M25 junction 28 improvement scheme

TR010029

9.29 Schedule of Changes to draft Development Consent Order

April 2021

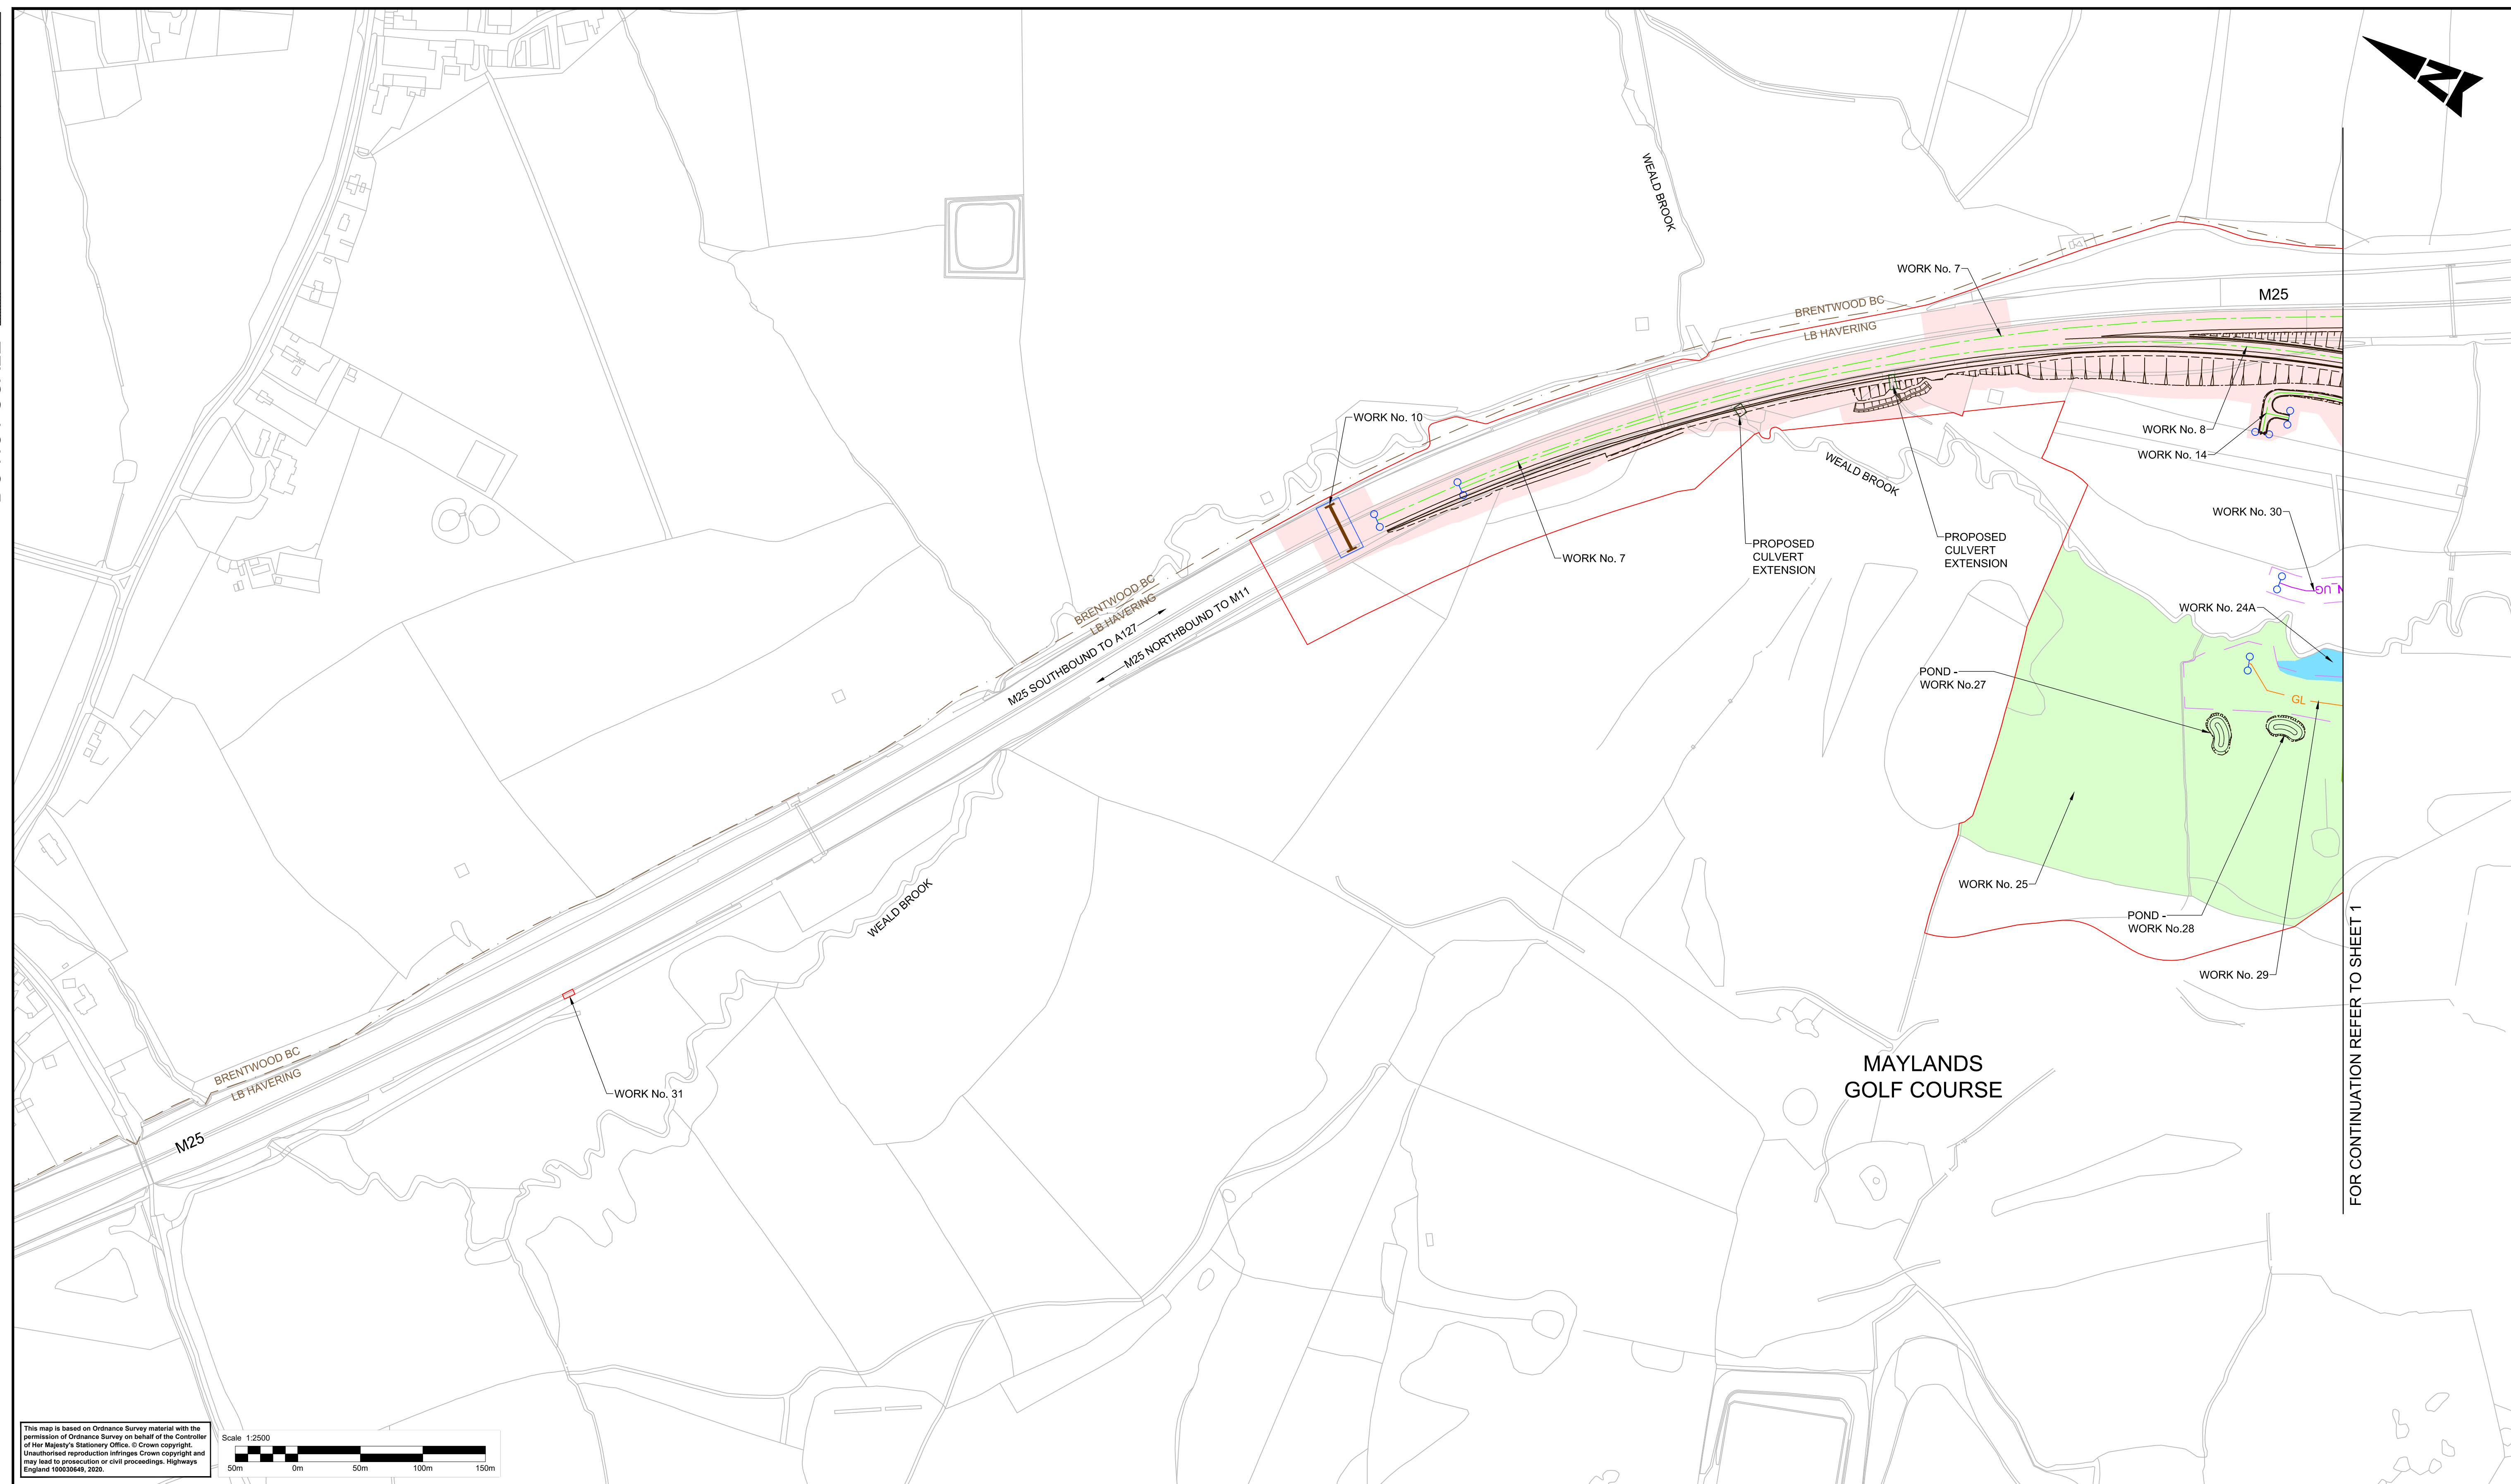
6.	Schedule 1	<p>Work No. 18 — Deposit of surplus construction materials, Construction of an environmental bund over an area of land approximately 23,100 25,565 square metres in area, at a location</p>	<p>Added following acceptance by ExA’s of Change 2.</p>

No	Provision	Suggested amendment	Explanation for change
		situated alongside the new loop road (Work No. 6) and to the north of Work No. 19B as shown on sheet 1 of the works plans.

FOR CONTINUATION REFER TO SHEET 1

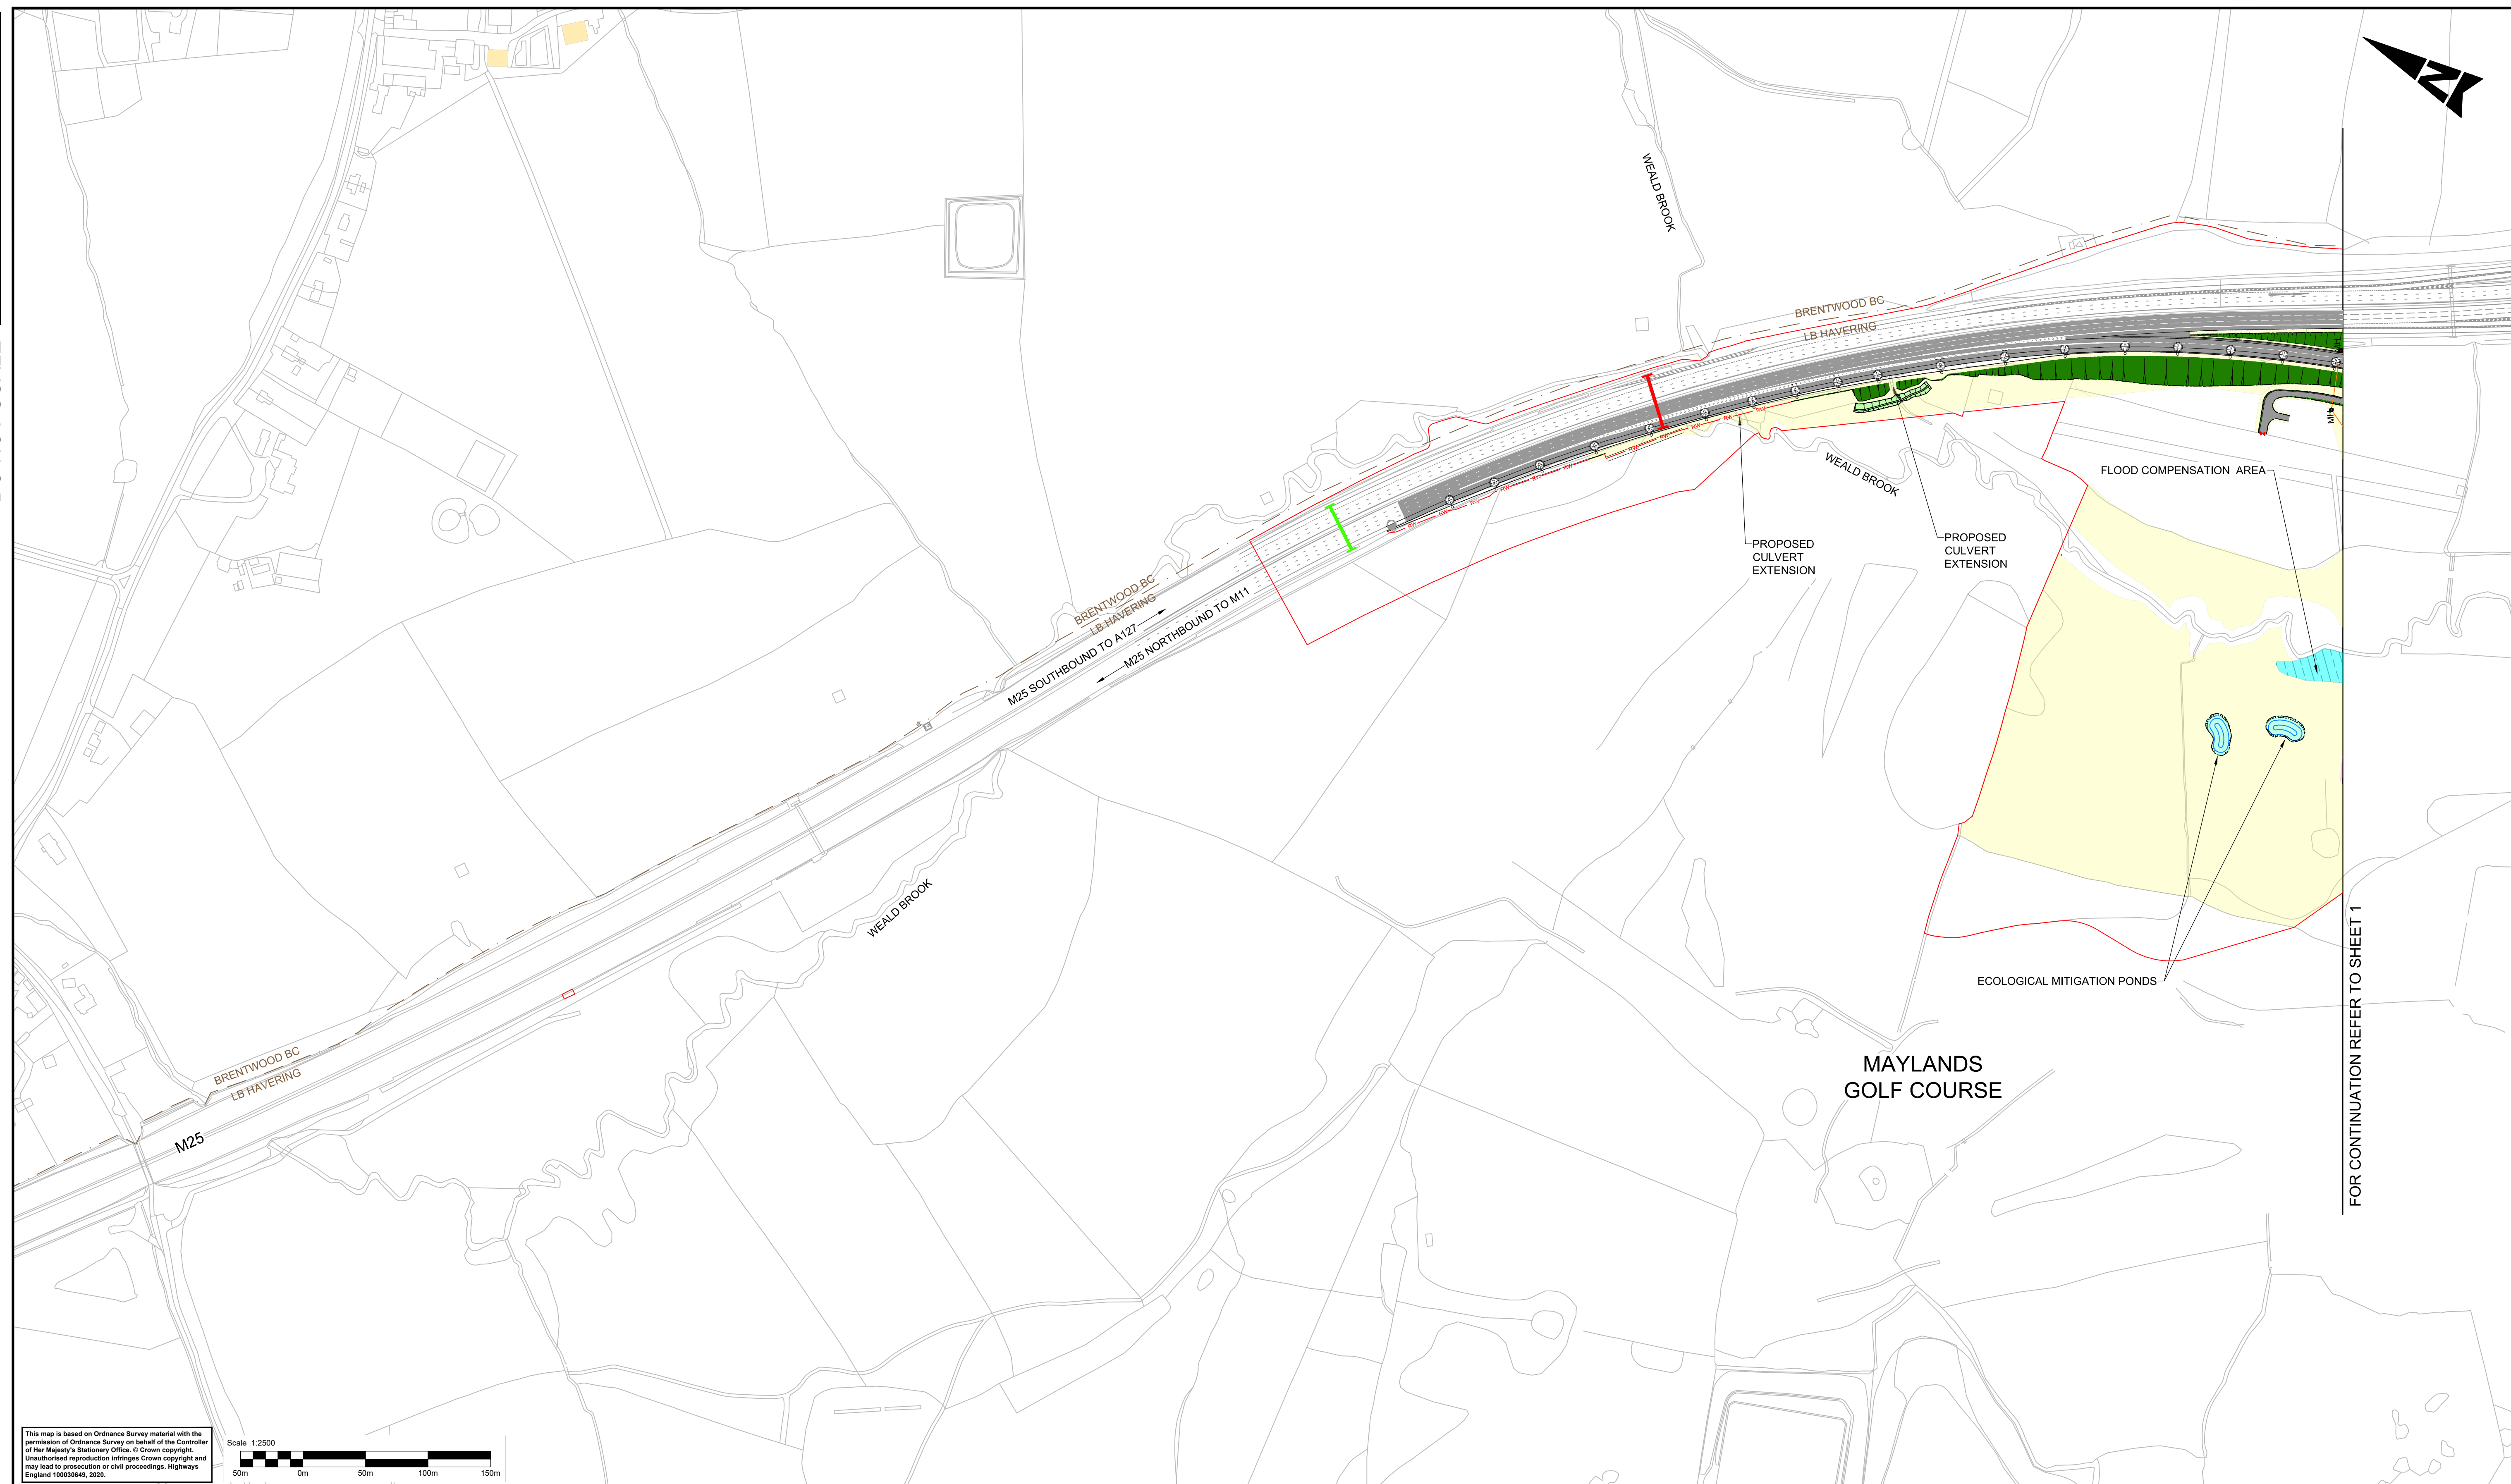
5.	Schedule 1	<p>Work No. 17 — Not used Deposit of surplus construction materials, over an area of land approximately 22,000 square metres in area, at a location situated to the west of Weald Brook as shown on sheet 3 of the works plans.</p>	<p>Added following acceptance by ExA’s of Change 1.</p>

7.	Schedule 1	Work No. 27 — A new pond, for environmental mitigation purposes, approximately 500 square metres in area, and situated at a location to the south of Work No. 17 north of Work No. 28 as shown on sheet 3 of the works plans.	Added following acceptance by ExA's of Change 1.
